FIRE RISK MANAGEMENT, INC.

Memo Report

Subject: **Updated Fire Hazards Assessment of the Liquid Riot Bottling Company at 250 Commercial St., Portland, ME.**

3 SECOND FLOOR PLAN  
SCALE: 1/8"=1'-0"

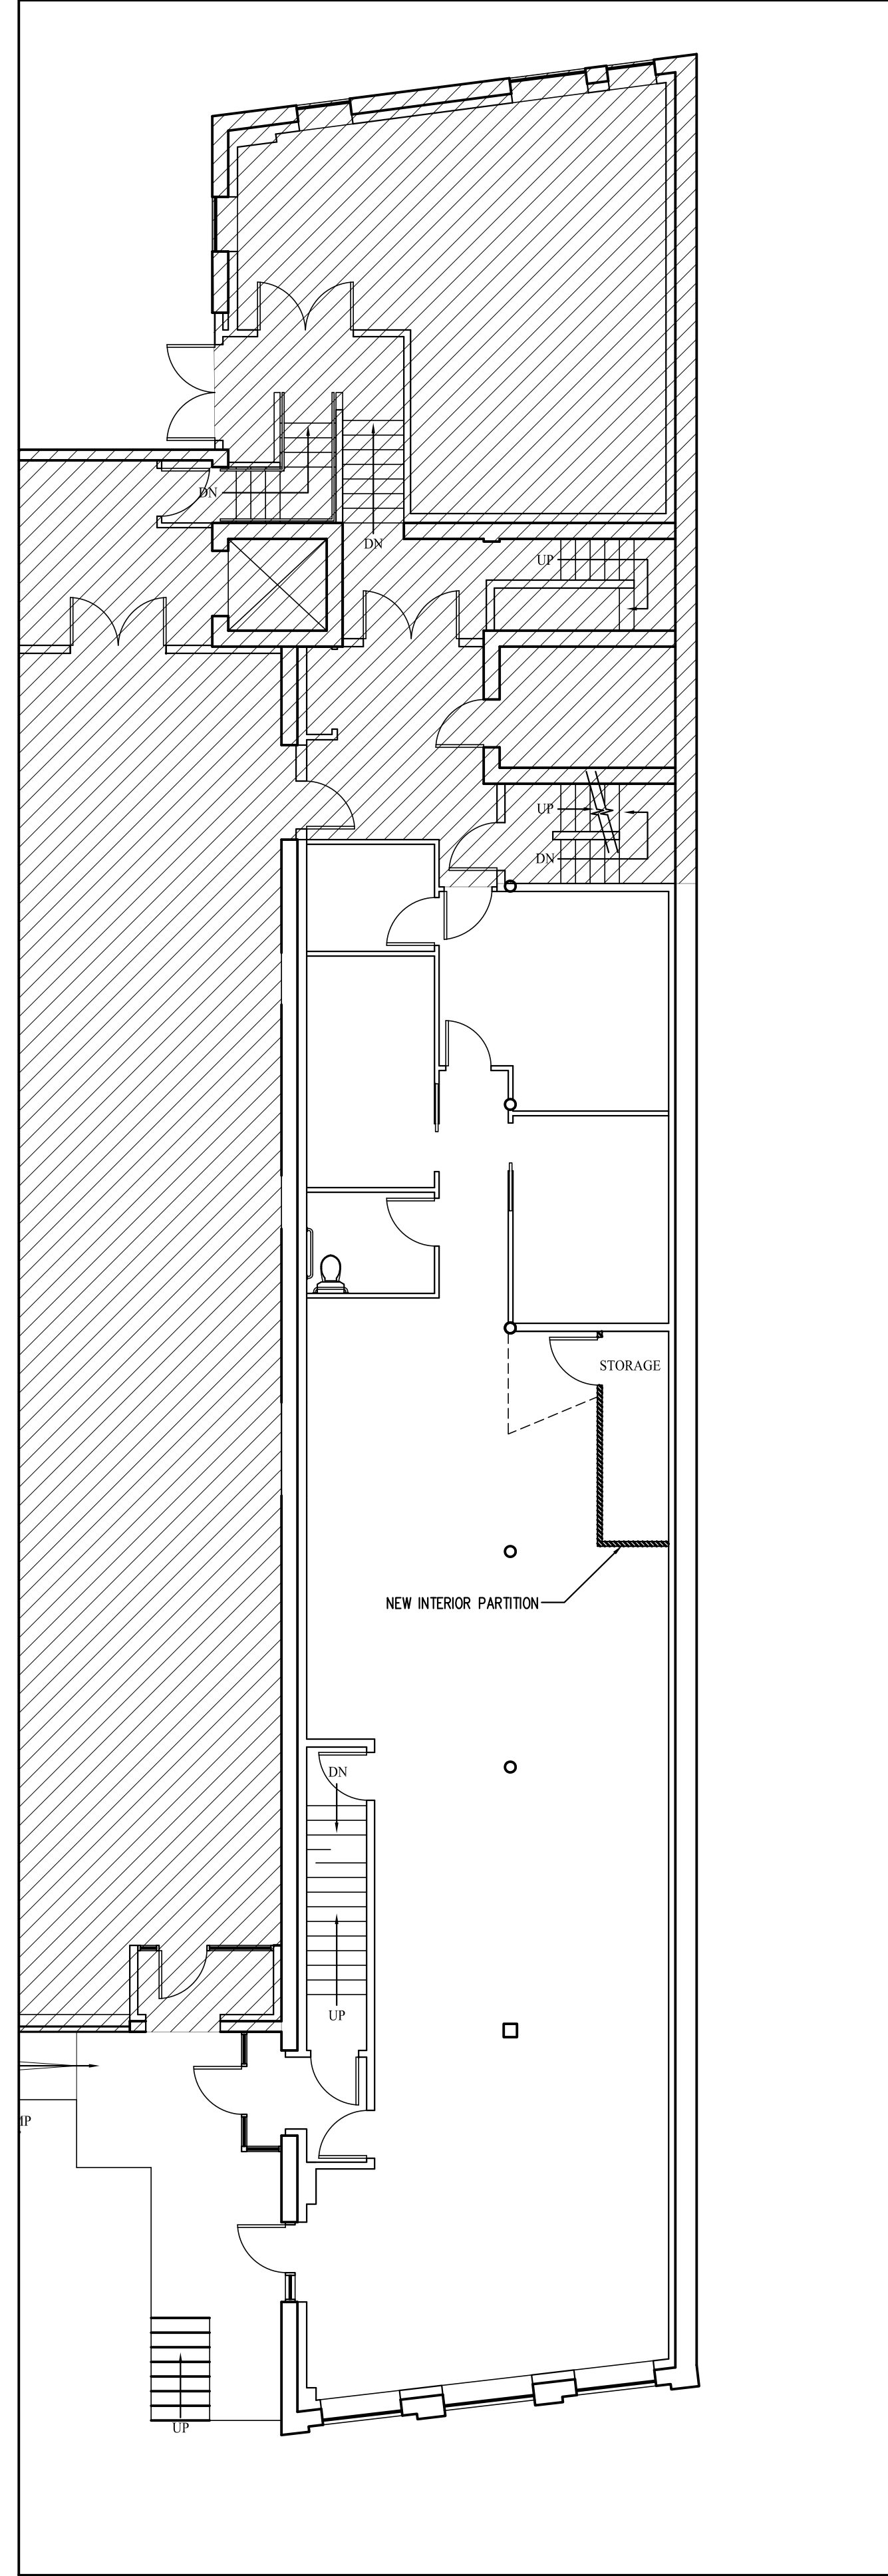
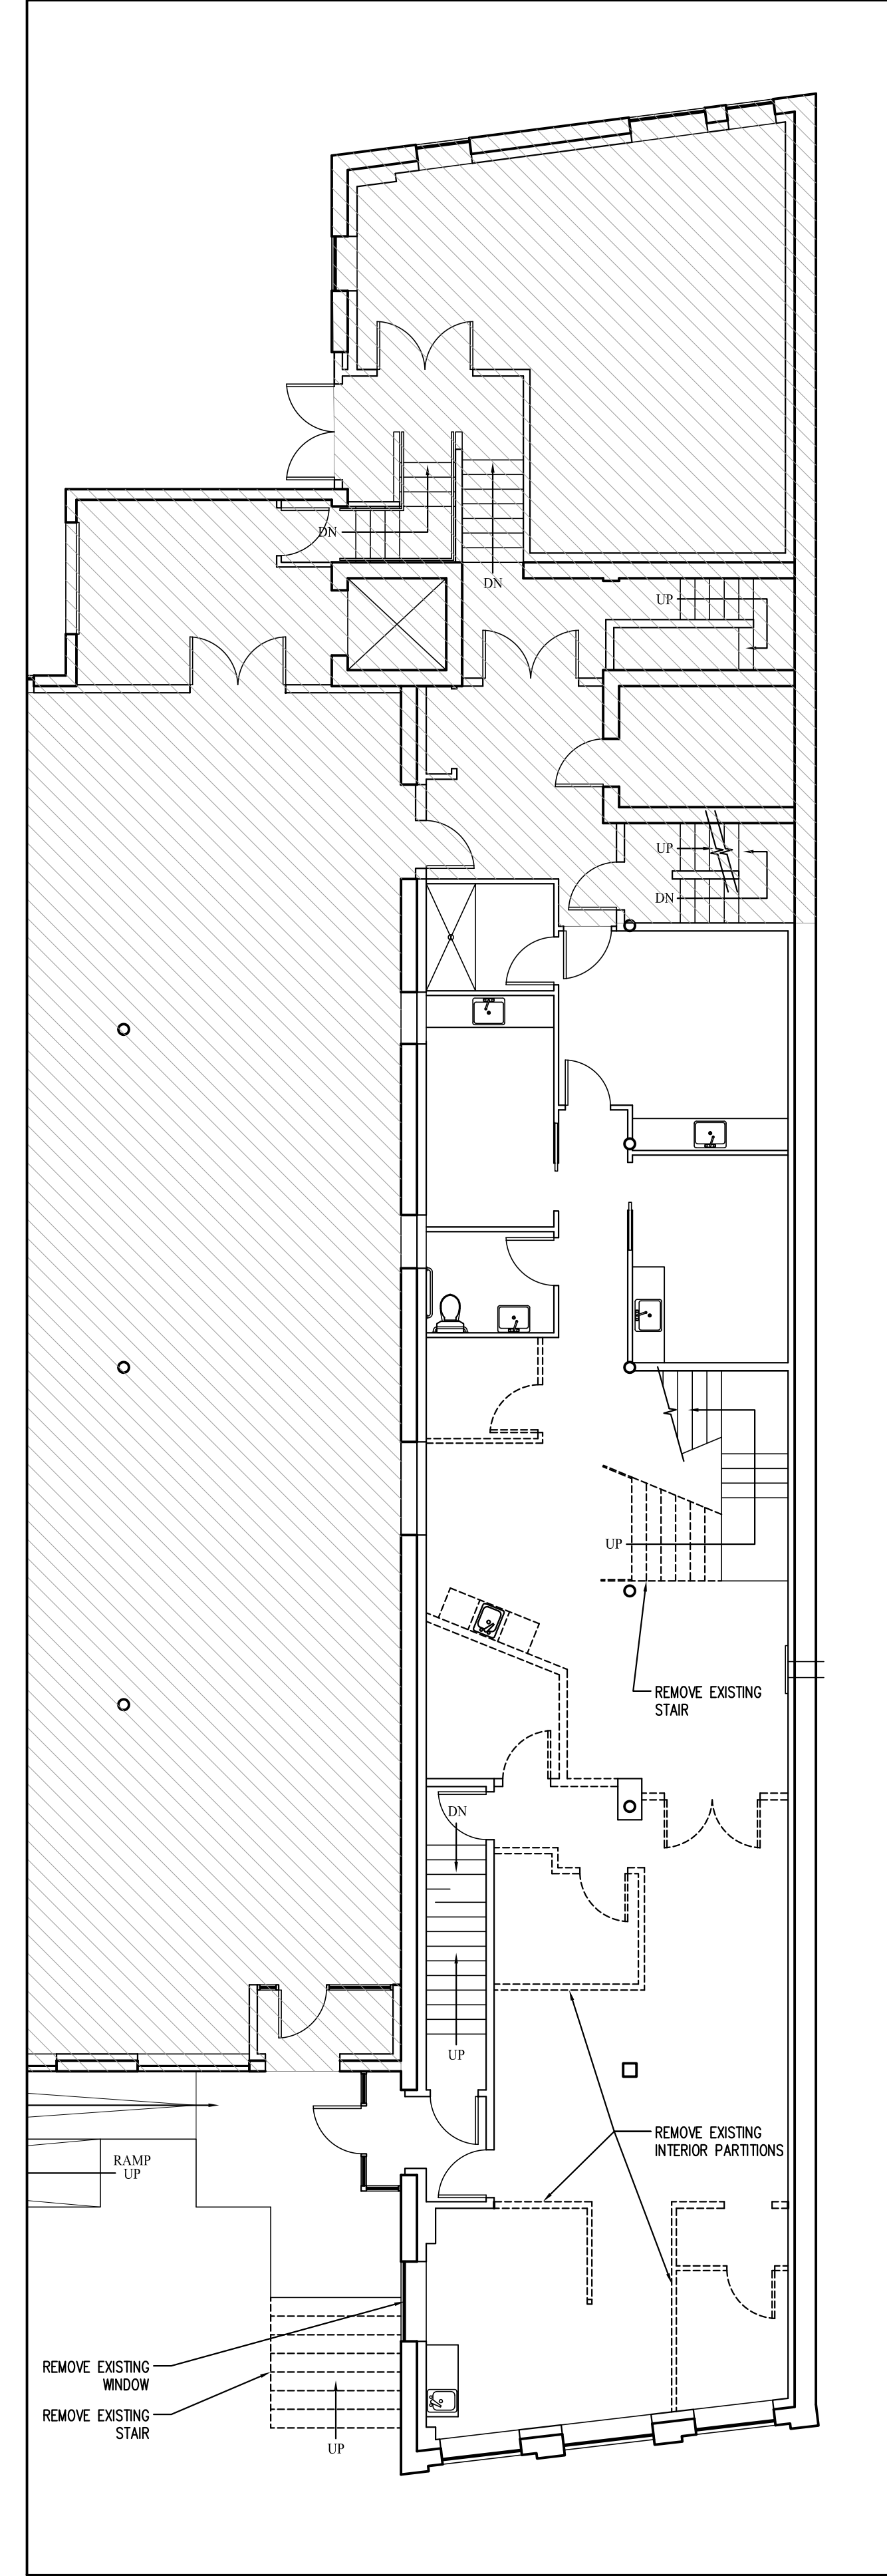
A review has been conducted of the updated layout/construction for Liquid Riot Bottling Company facility, which includes a small distilling operation, along with the addition of a new storage area for distilled spirits that are being aged in wood barrels. The new barrel storage space is to be located on the 2nd floor level of the facility, which is located at 250 Commercial Street in Portland, ME. The primary purpose of this updated review is to evaluate the current (as-built) configuration of the brew pub facility and evaluate any potential code compliance issues associated with the addition of the new barrel storage area on the 2nd floor level.

The building appears to generally meet the requirements of a Type IIB construction, as defined by the IBC. The exterior walls are all listed as being of masonry construction; nominally 8 inches thick. The floor/ceiling assembly that separates the 1st and 2nd floors consists of a concrete slab that is supported by exposed steel beams and columns. The space that is to be dedicated for the distilling operations is located along a portion of the northwest exterior wall; that adjacent to Commercial St. The barrel storage room is to be located at the northeast corner of the 2nd floor area.

1. Ensure the new barrel storage area is separated from the remainder of the facility by barriers that have a fire resistance rating of at least one hour.
2. Ensure that anytime flammable liquids are being transferred between containers within the distilling area that a portable fire extinguisher is readily accessible within this area.
3. Transfer of barrels from the distilling area to the 2nd floor storage room should be limited to periods when the facility is not open for public occupancy.
